Planning Application: 3/2026/0536

Proposal: Approval of details reserved by condition 5 (programme of archaeological work for the site of the temporary River Hodder Crossing and associated haul road and compounds of planning permission 3/2021/0660.

STRABAG's Written Scheme of Investigation, is lacking the following:

Figure 1 Phase 1 - Enabling and Site Establishment Works associated with the River Hodder Crossing

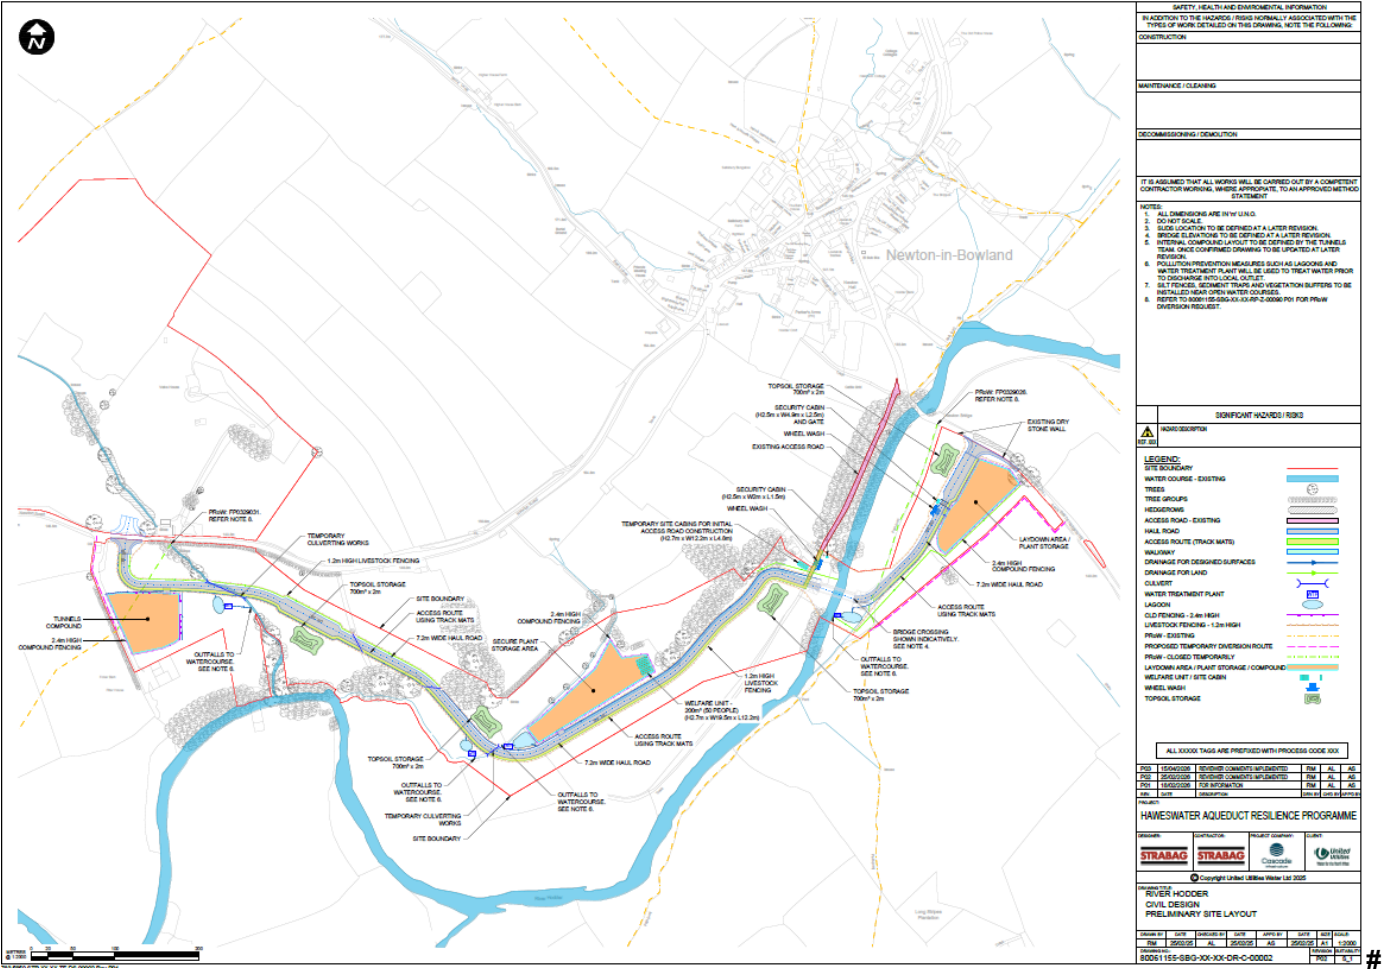
a revised Figure 1 that more clearly shows all the proposed phases of work (masterplan), or by a set of plans showing each individual proposed phase.
